KITTITAS COUNTY DEPARTMENT OF PUBLIC WORKS

TO: Ms. Kelly Bacon, ET I
COPY: Lucas Huck, County Road Engineer
DATE: May 15, 2017
FROM: Mark R. Cook, Director 
RE: Currier Heights

SHEET CONTENTS
SITE PLAN

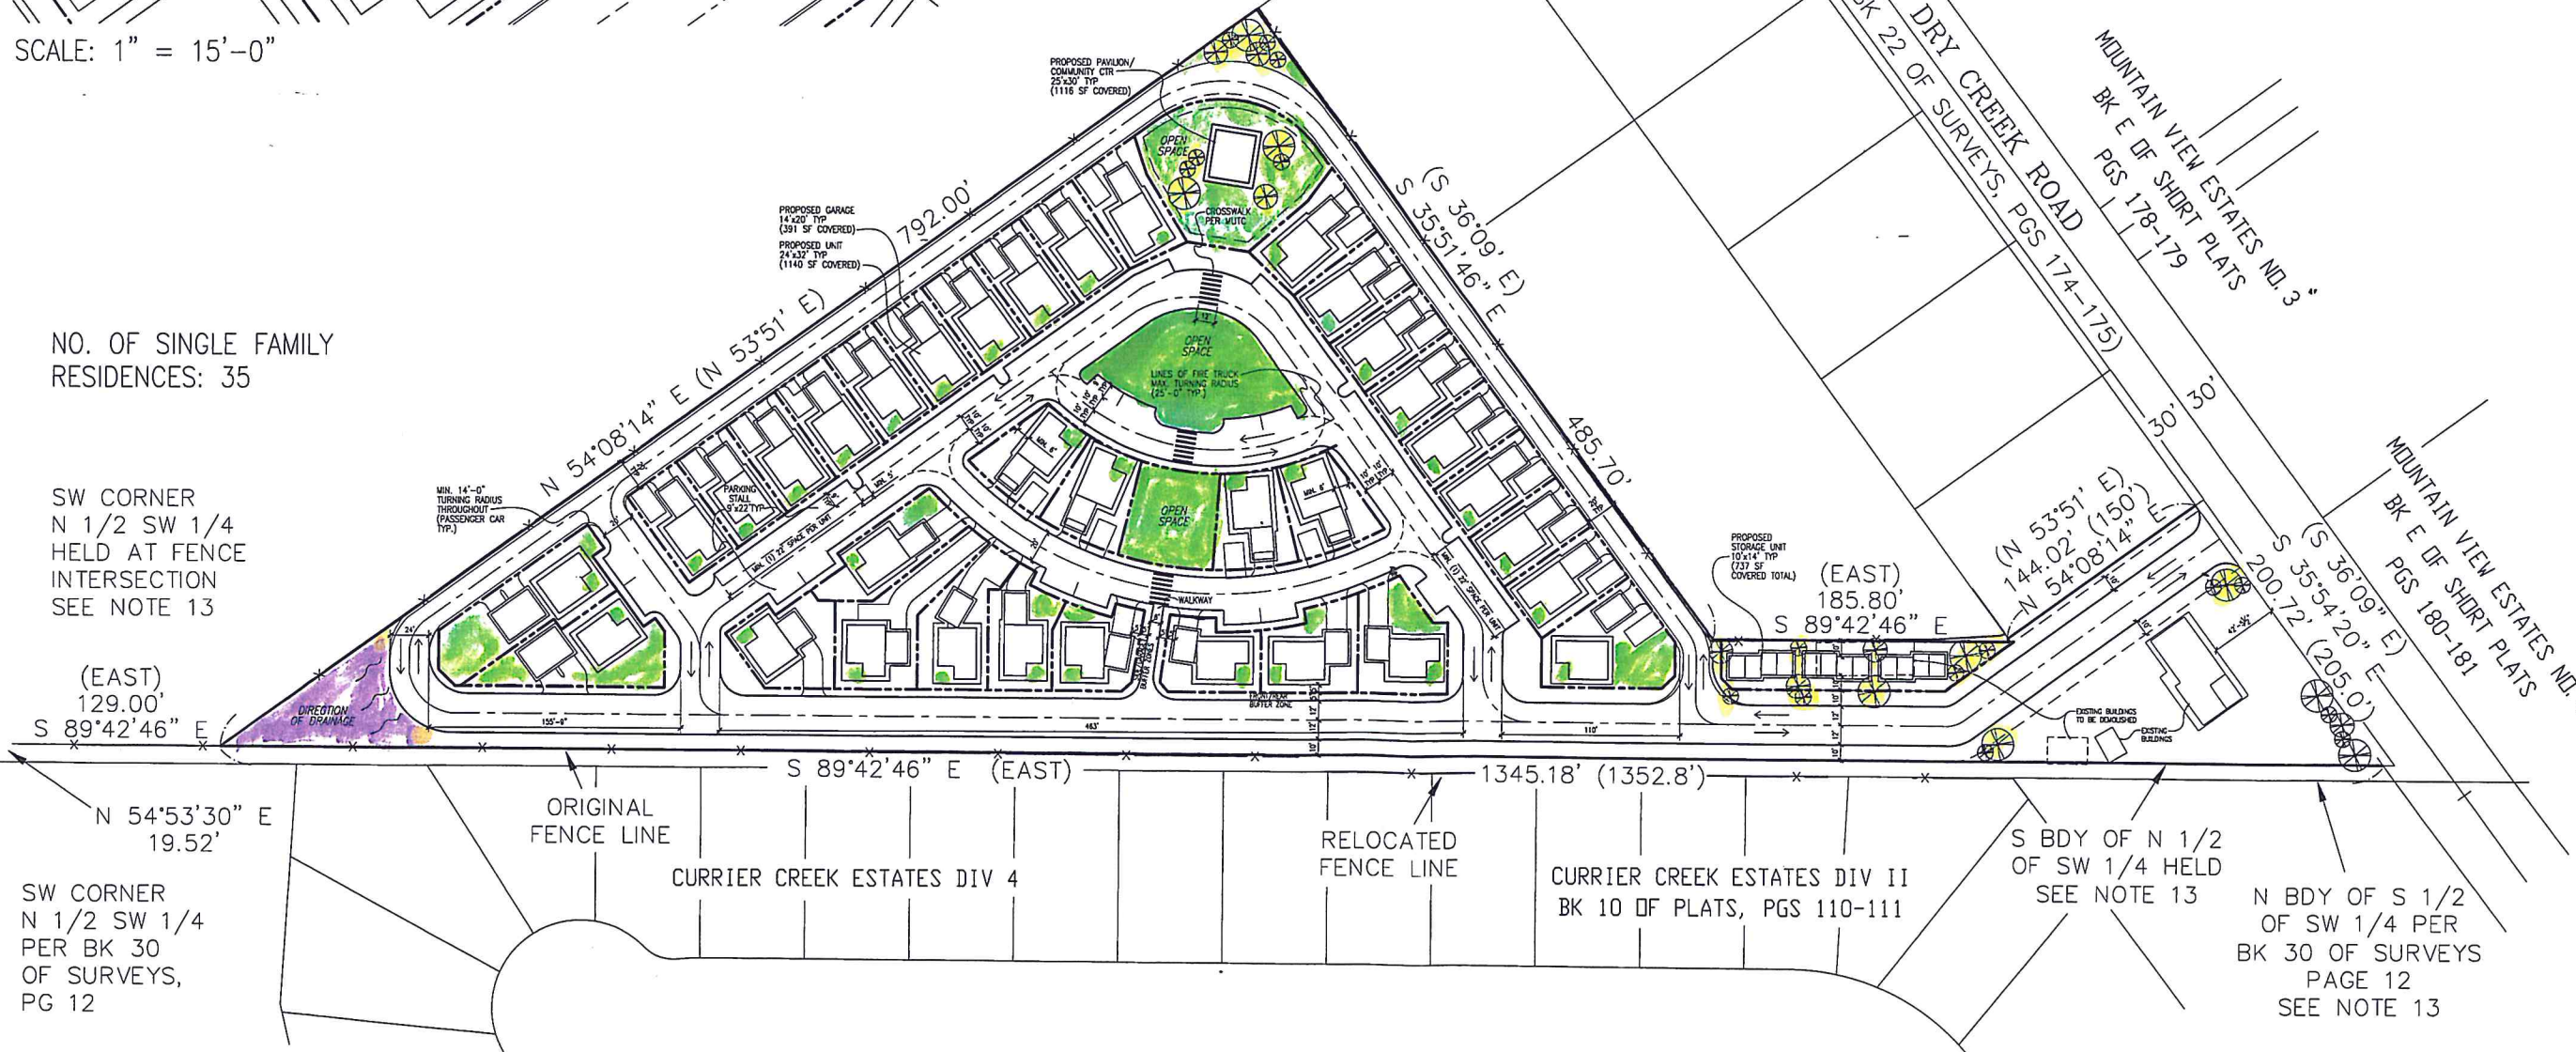
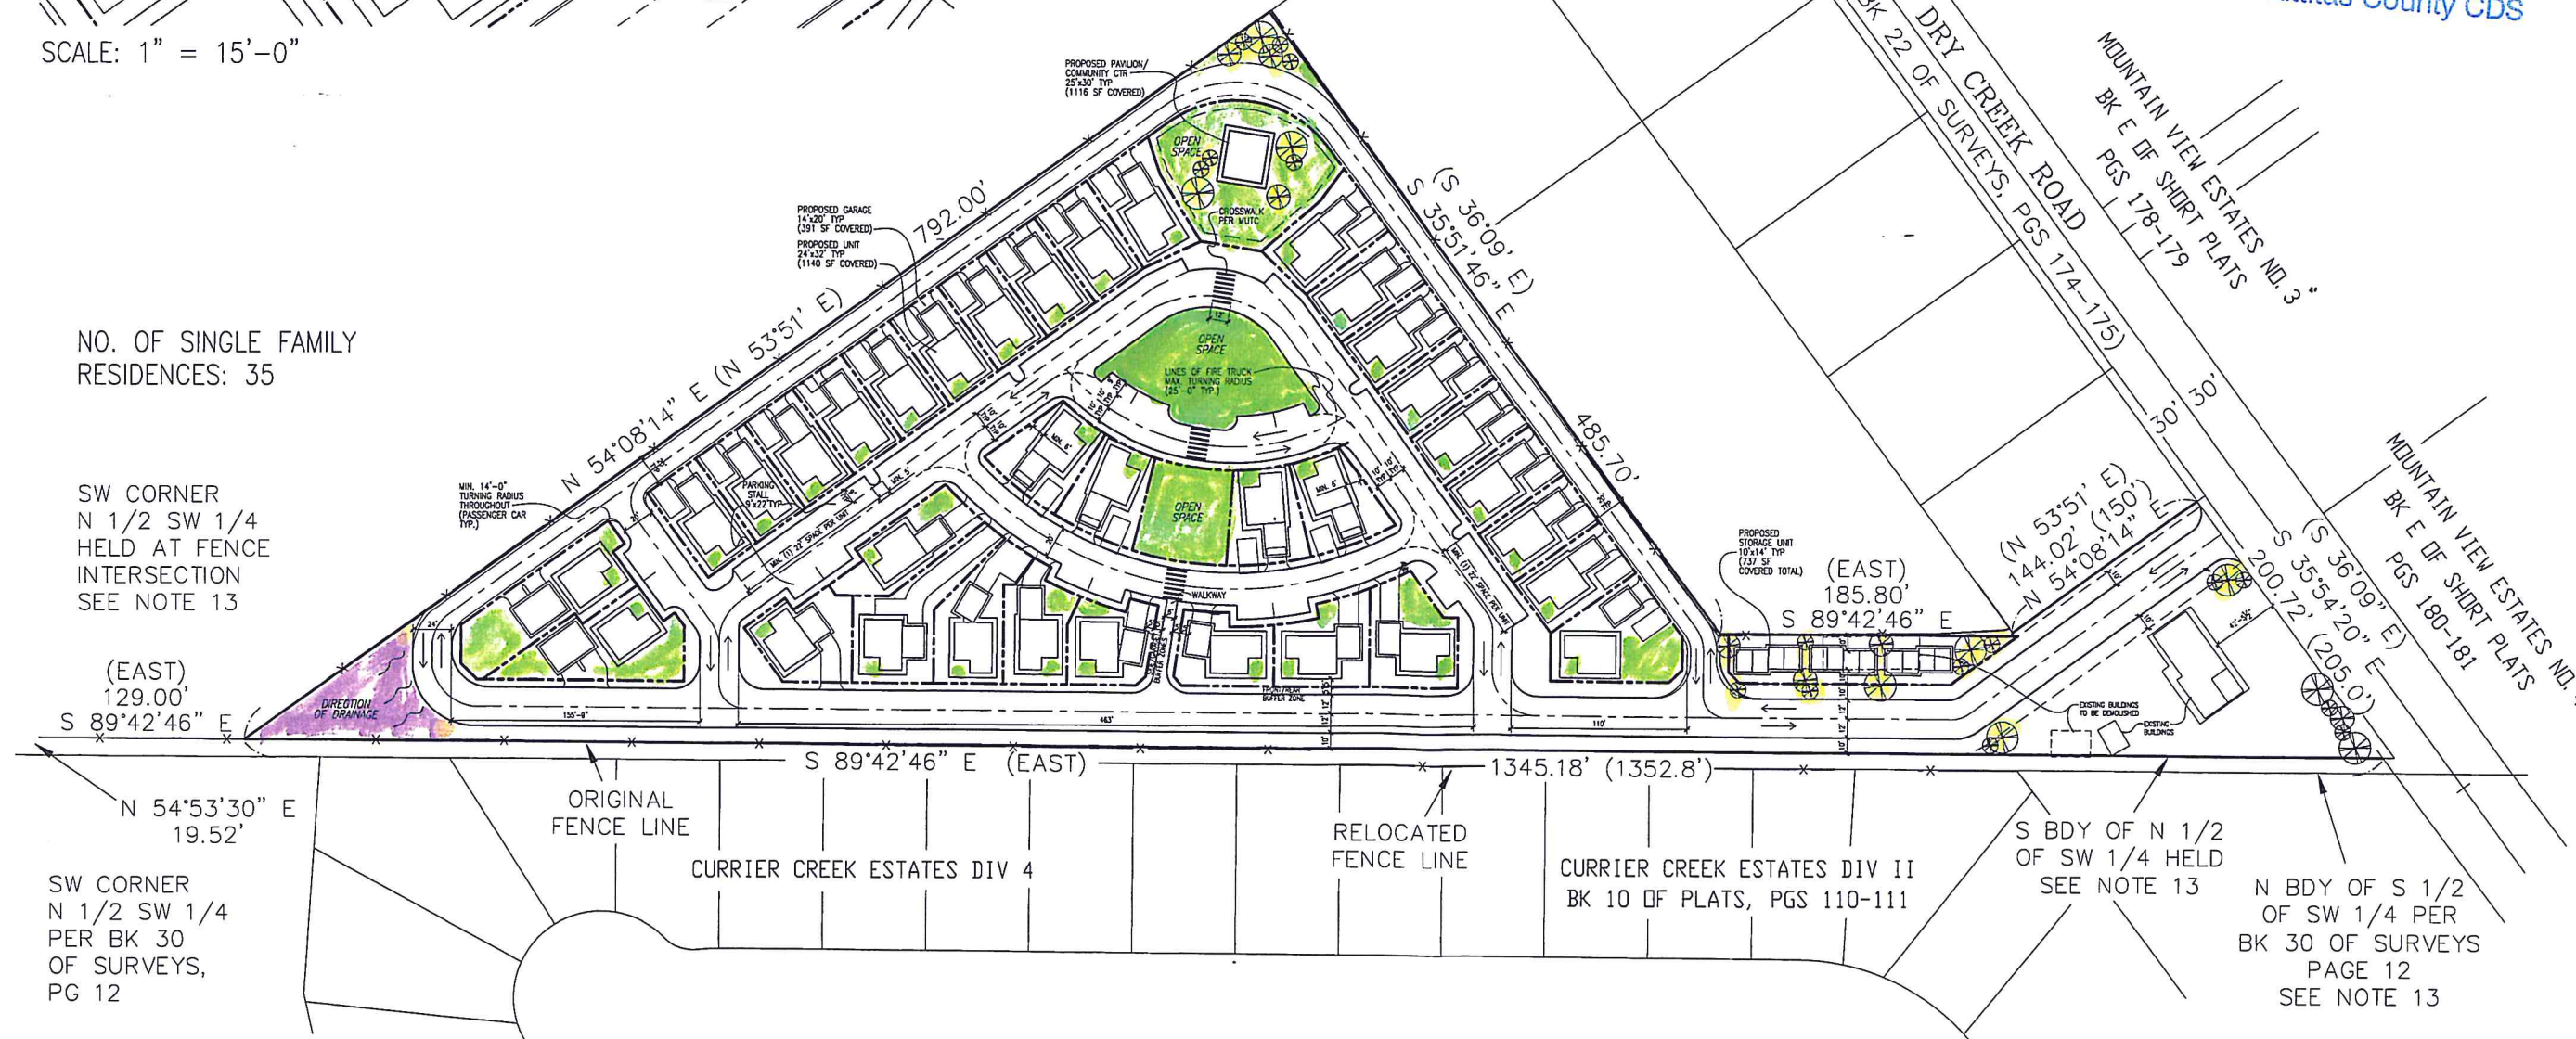
1. Kittitas County Code 12.04.040(b) (Design Criteria within an Urban Growth Area) affords final approval of the road alignment, geometry and construction requirements to the City of Ellensburg (Currier Heights). This same section references the "more stringent" of the County or City standards apply. Taken together, I interpret our code to mean the County's right of way requirements together with the wider of the two jurisdiction cross-sections with curb-gutter-sidewalk on all roadways. Given this requirement, the proposal provides far too little detail to comment further on the road proposal serving the plat. The submitted materials are insufficient for further staff review.

2. The plat is located in a known area of flooding. Two recently purchased homes in Currier Creek Estates proximate to this proposal have experienced flooding this past spring. The proposal is insufficient in detail allowing me to understand how runoff from the site will be mitigated. It is likely that no offsite discharge will be allowed from the site given known flooding in the area. The submitted materials are insufficient for further staff review.

3. I have been provided data suggesting that the site contains freshwater emergent wetlands. The provided plat map makes no notice of associated wetlands. The presence of potential wetlands further complicates the stormwater treatment and disposal scheme supporting plat development. The submitted materials are insufficient for further staff review.
